<b>Application Ref:</b>	3/2026/0217			 <b>Ribble Valley Borough Council</b> <a href="http://www.ribblevalley.gov.uk">www.ribblevalley.gov.uk</a>
<b>Date Inspected:</b>	28/04/2026	<b>Site Notice:</b>	28/04/2026	
<b>Officer:</b>	MC			
<b>DELEGATED ITEM FILE REPORT:</b>				<b>REFUSAL</b>

<b>Development Description:</b>	Reserved matters application relating to appearance, landscaping, layout and scale following outline planning permission 3/2025/0289.
<b>Site Address/Location:</b>	Thornley Hall Farm, Up Bedlam Road, Thornley, PR3 2TN

**Title:** Proposed Site Plan  
**Drawing No:** Air/1164/3803 - 03 **Drawn:** MP  
**Client:** G.E. Airey & Sons  
**Date:** 18.03.2026 **Scale:** 1:200 @ A1  
**Amendments:**

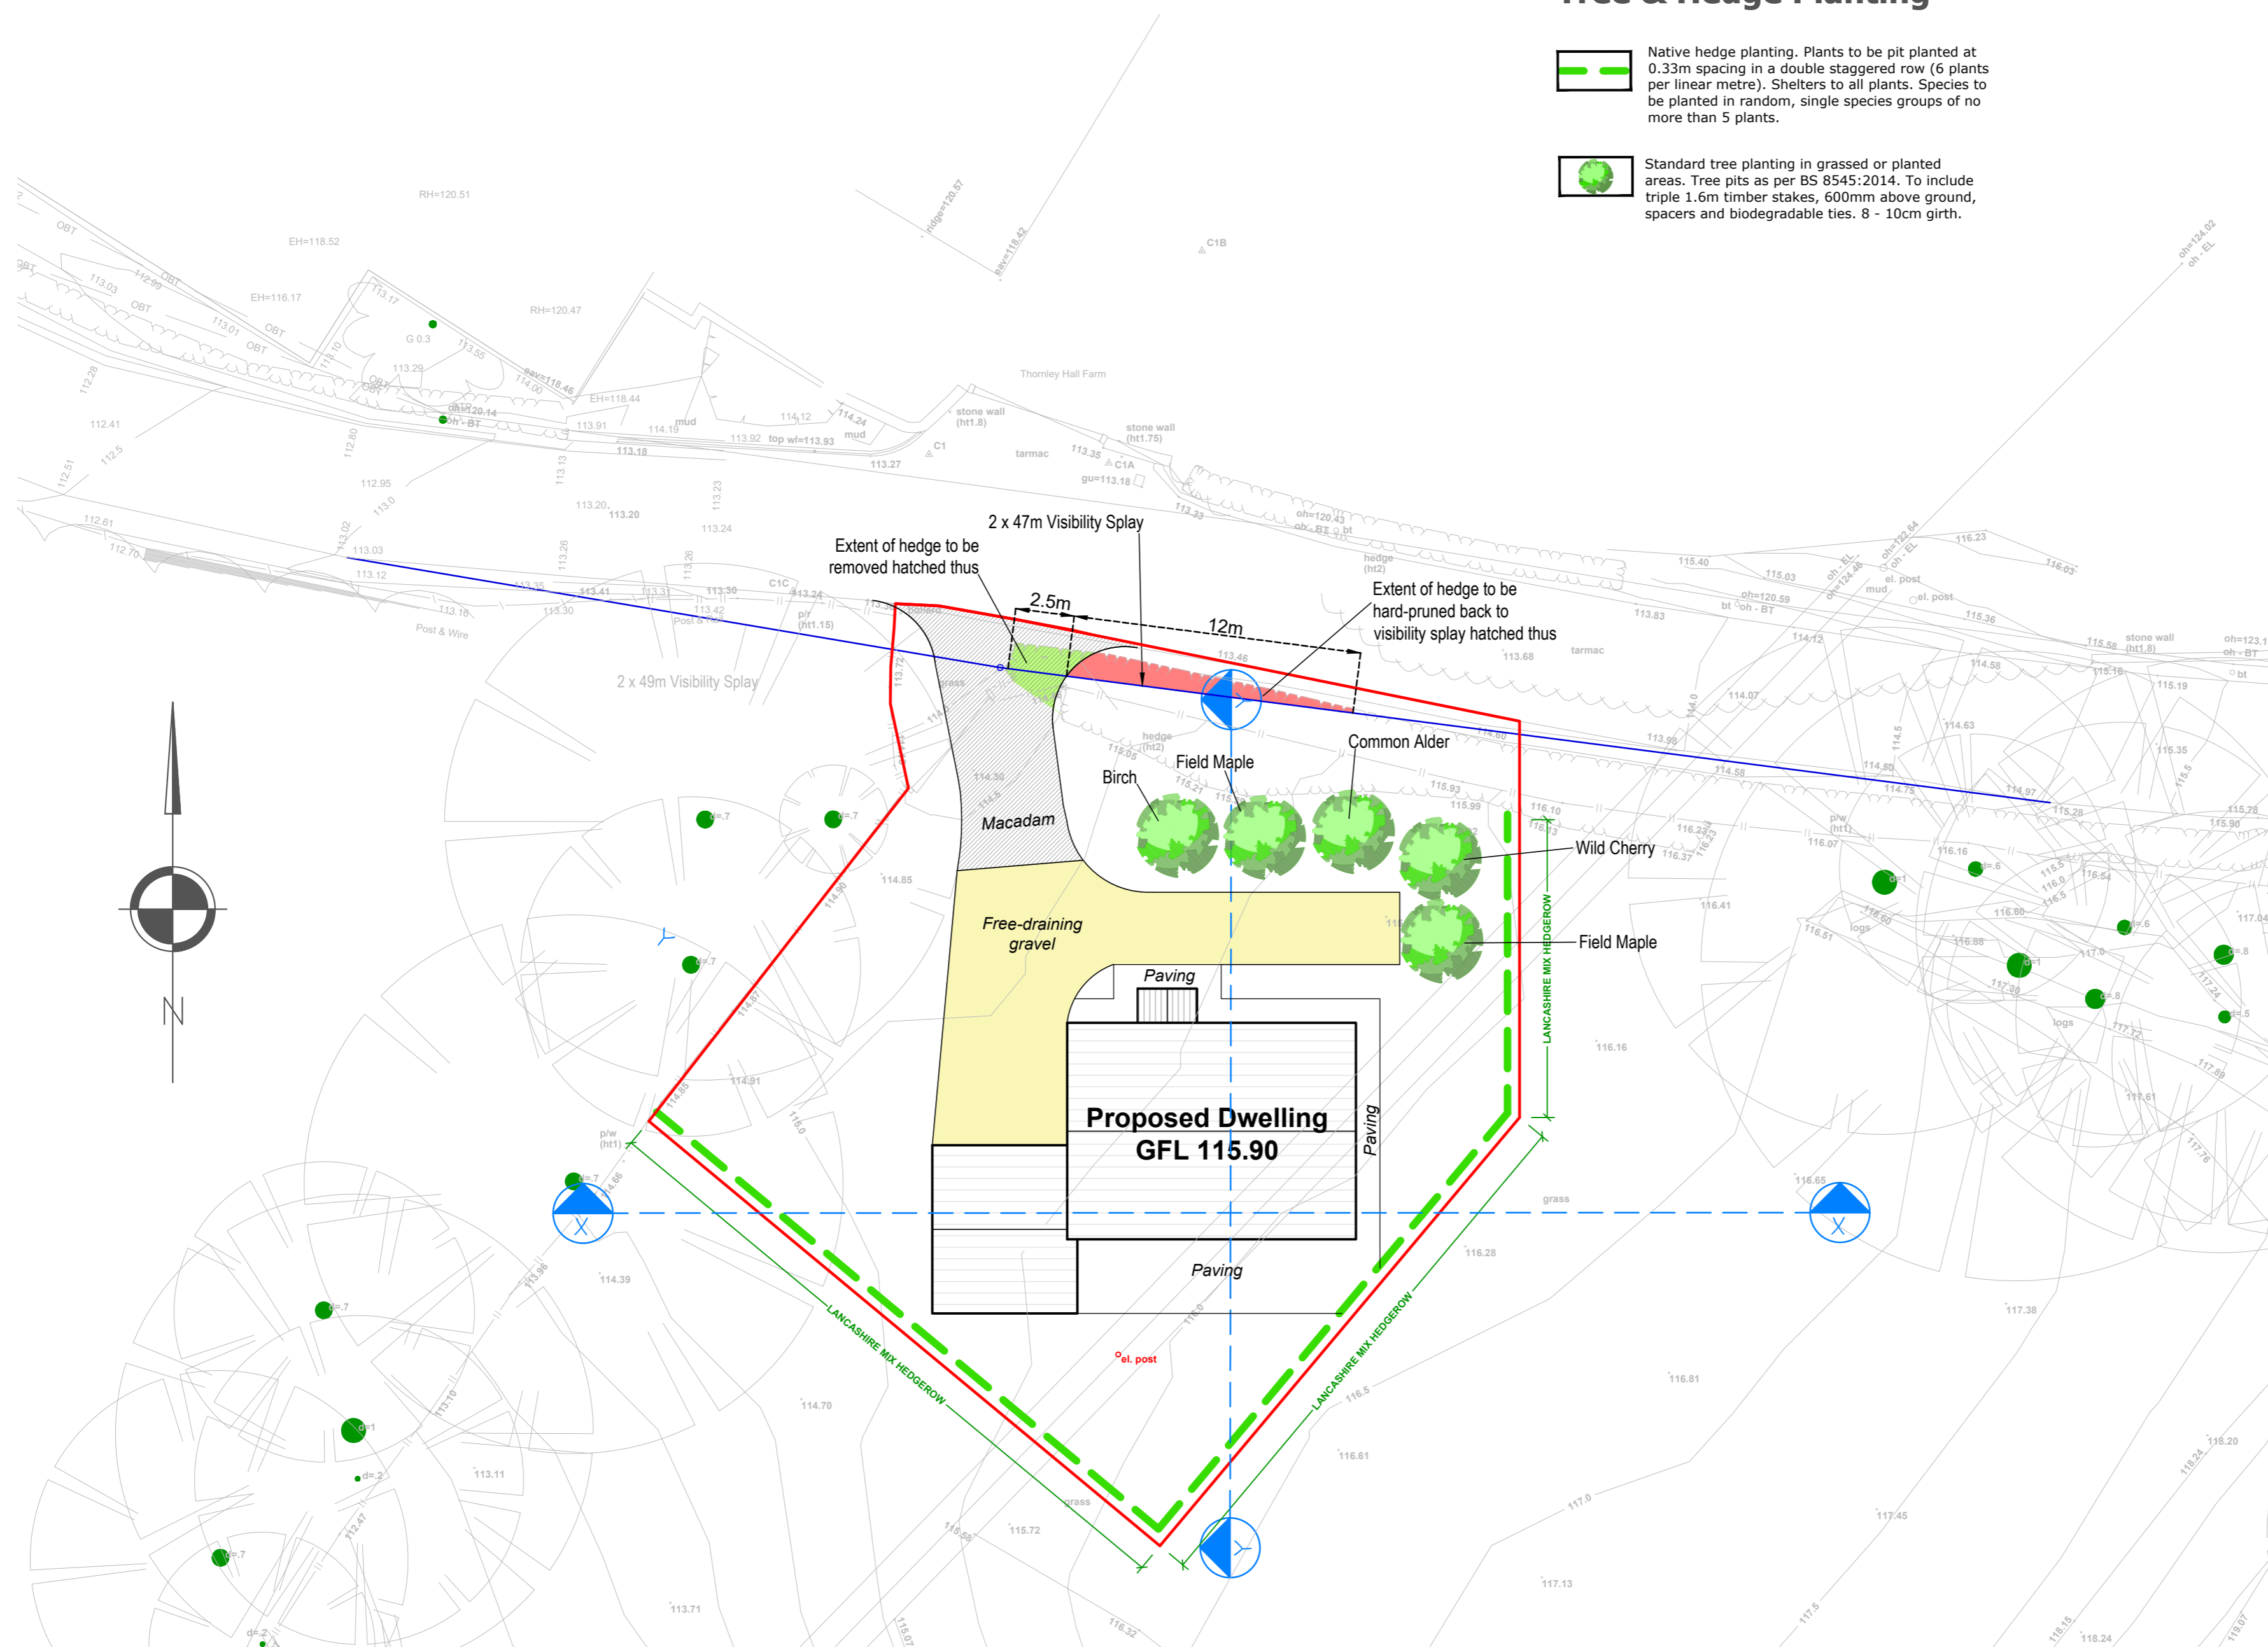
It should be noted that a reserved matters application has been recently granted under planning ref: 3/2025/0848. However, the applicant is now seeking to re-orientate the dwelling and amend the location of the attached garage so that the dwelling now sits parallel to the road, with the garage being sited off the western flank wall and set back by approximately 5.1m from the front of the dwelling.

The orientation and design of the dwelling have been amended so that the dwelling now has its principal frontage parallel to the road, with the ridge running east to west, rather than north-east to south-west. In addition, the garage would now be sited on the opposite flank wall to as previously approved under planning ref: 3/2025/0848.

In contrast, the reorientation of the dwelling with the ridge running from east to west is not considered to be in keeping with the existing pattern of development within the vicinity of the site or relate well to its site boundaries. Due to its amended orientation, the dwelling would now appear more prominent in its surroundings and would reduce the open views through the site from the road. The two-storey principal frontage would be forward of the single storey garage element and would run across the site parallel to the road resulting in a greater scale and massing evident from the road. The fenestration detailing facing the highway also contributes to a greater prominence, including large feature landing window - in contrast the previous scheme had fewer and smaller windows facing the highway. Additionally, the proposed finished floor level is slightly higher compared to the previously approved scheme. The linear form of landscaping proposed in front of the dwelling is more contrived compared to the previous grouping of trees secured. The resultant changes are considered to result in a design which does not respond sympathetically to its surroundings, in particular a prominent building elevated from the road with reduced views across the site.

As such, it is considered that the amended scheme would result in a harmful visual intrusion, into an area that comprises a fairly open landscape when compared to the approved scheme. As such, it is not considered that the amended scheme would protect, conserve and enhance the landscape and character of the Forest of Bowland National Landscape, nor would it contribute to the conservation of the natural beauty of the area and would result in an incongruous addition within the landscape that is out of keeping with the pattern of development within the local vicinity.
